From: Juan Baeza
Sent: 30 August 2017 10:10
To: Planning.Responses
Subject: FW: A/87/17/L & A/88/17/HH - The Old Cottage, Station Road, Angmering BN16 4HY

From: Ian Wightman [REDACTED]
Sent: 22 August 2017 12:34
To: Russell McCourty
Cc: David Easton; Juan Baeza; Mark Jones; John Hinds; Liz Galloway; Emma Weaver
Subject: RE: A/87/17/L & A/88/17/HH - The Old Cottage, Station Road, Angmering BN16 4HY

Thank you for the revised drawings showing amendments to the extension. Given the improvements to the south elevation we are now in a position to support this design.

SIDE ELEVATION
SOUTH

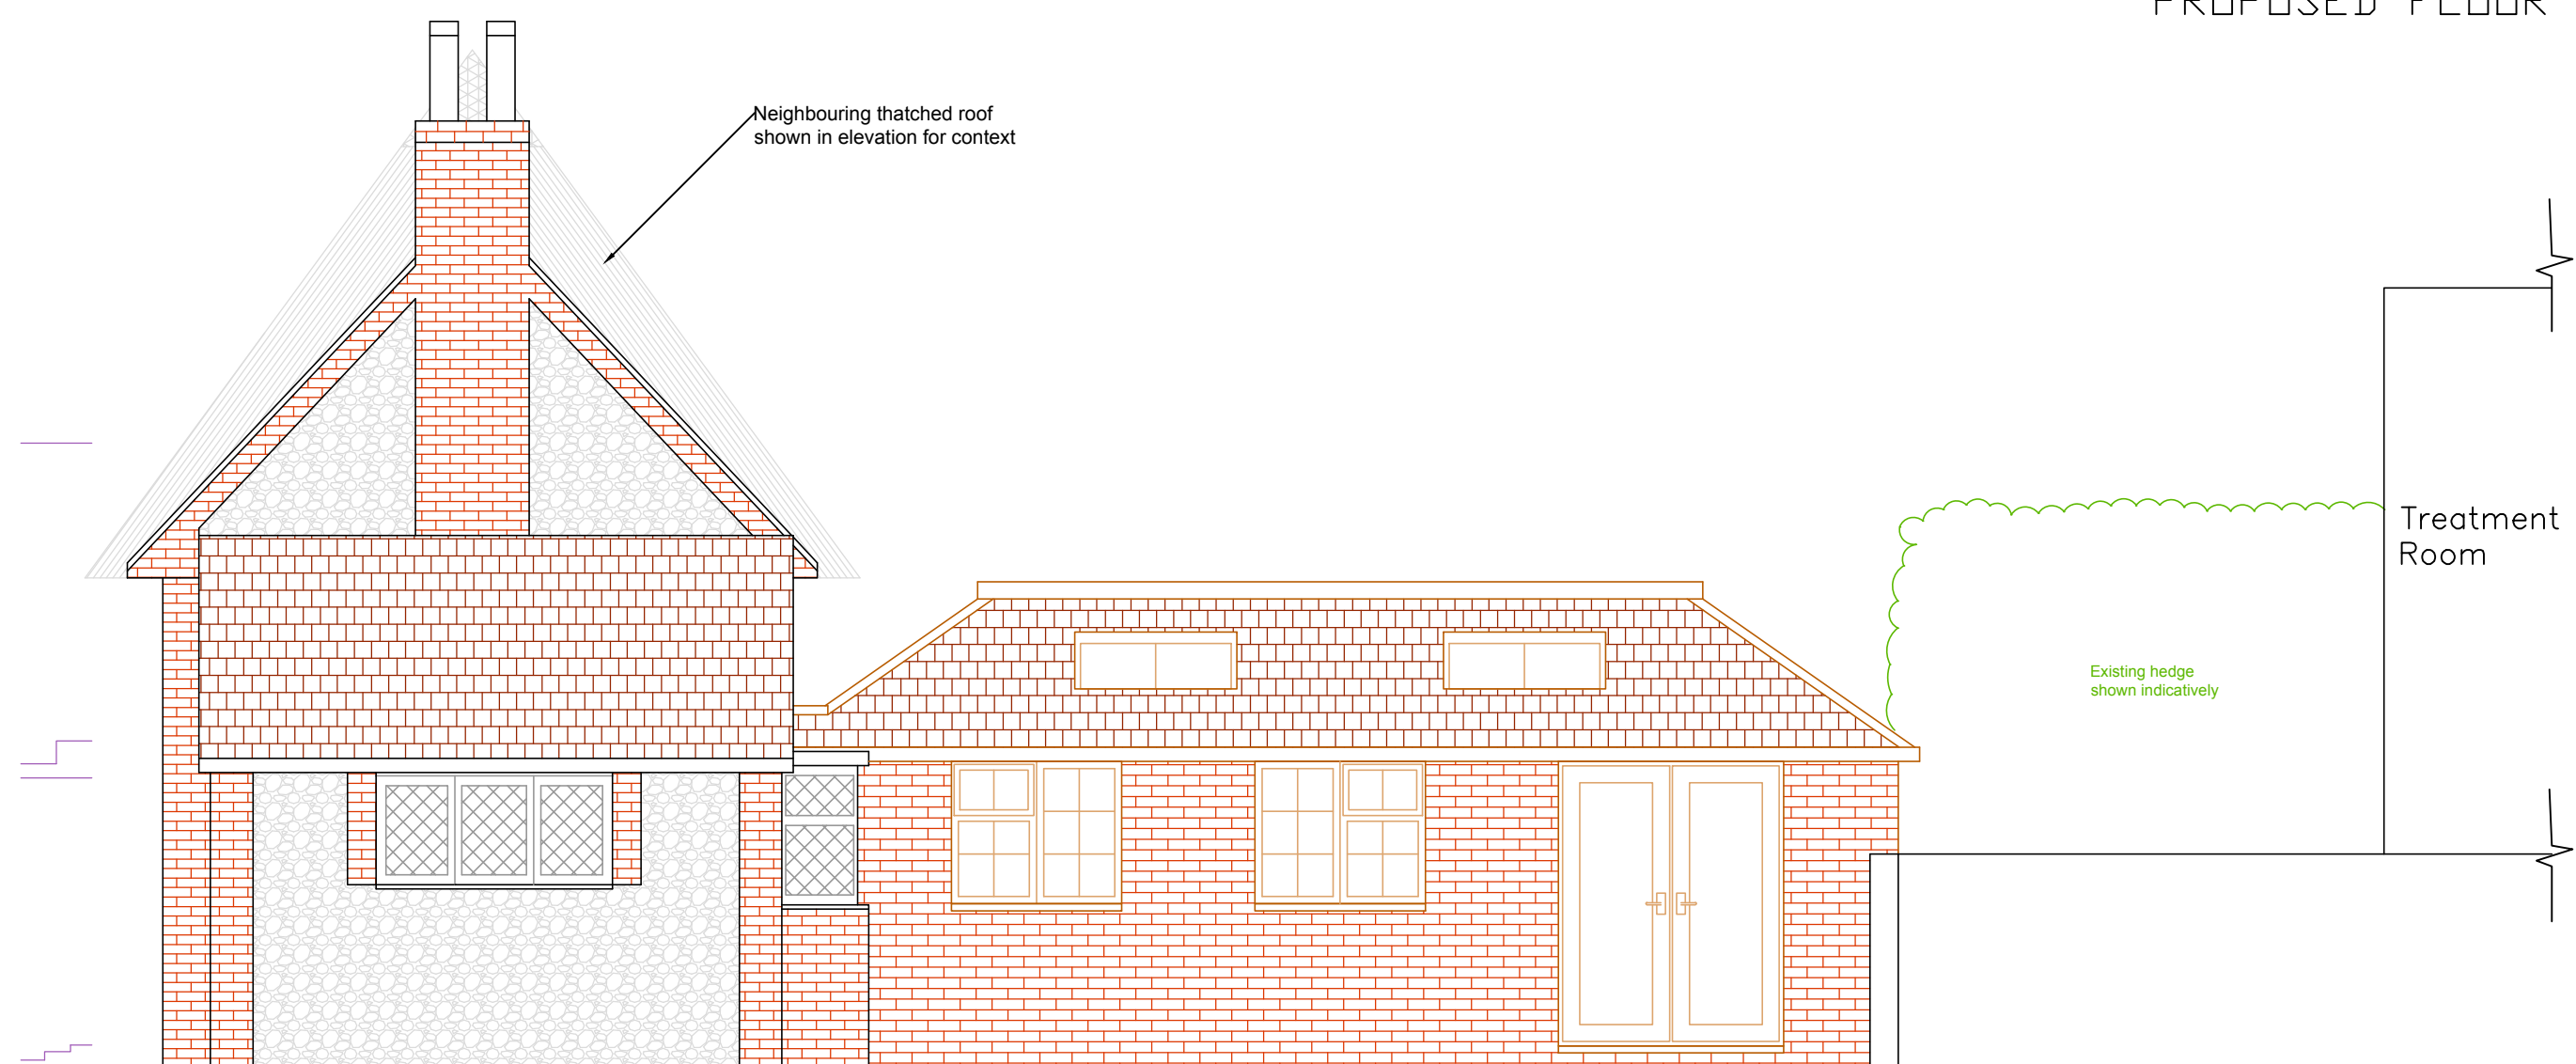
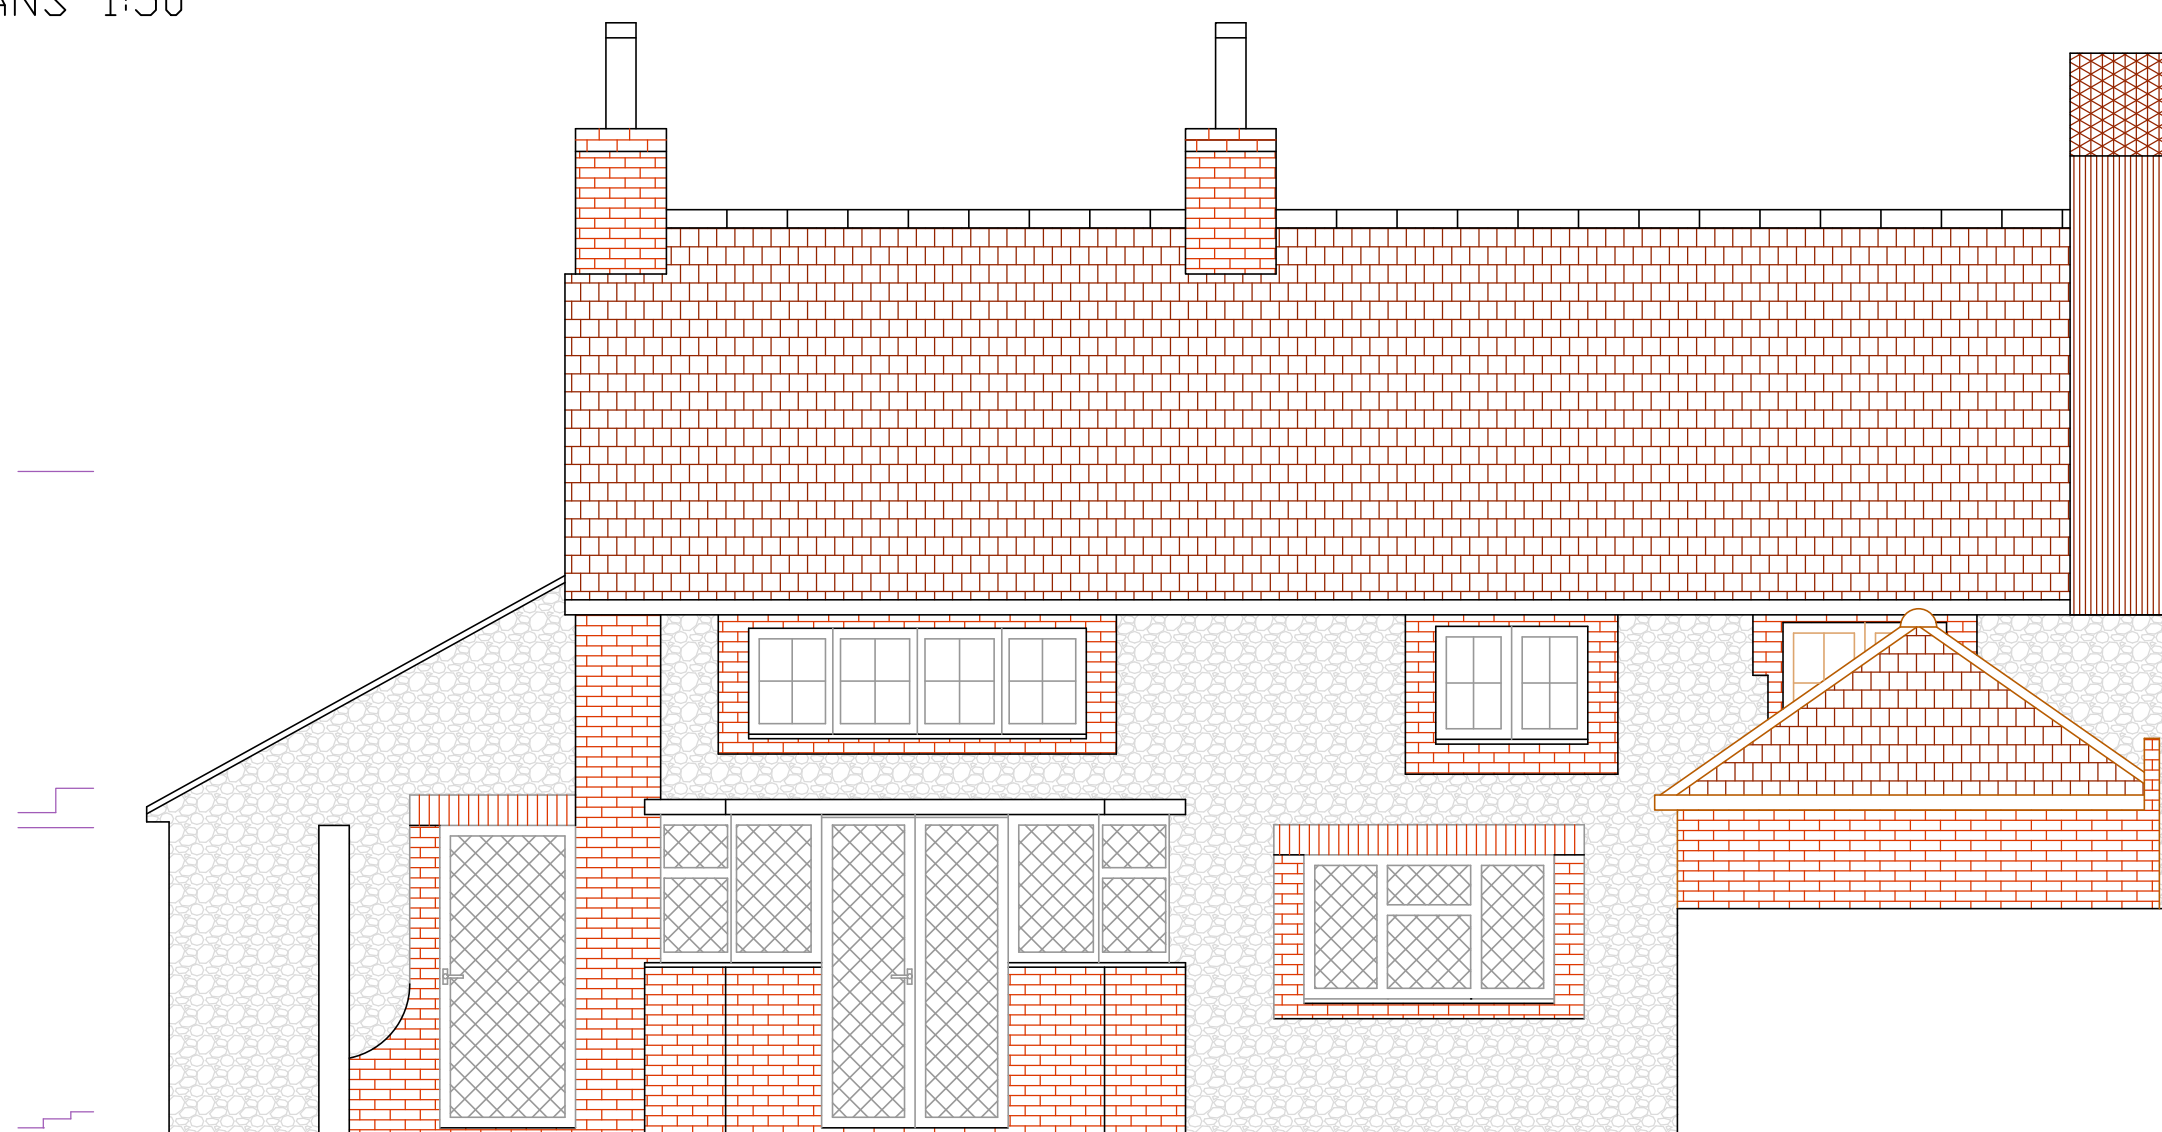
We will require a condition for the brickwork and to this end you might want to consider Flemish or English bond which will add some interest without being too complicated.
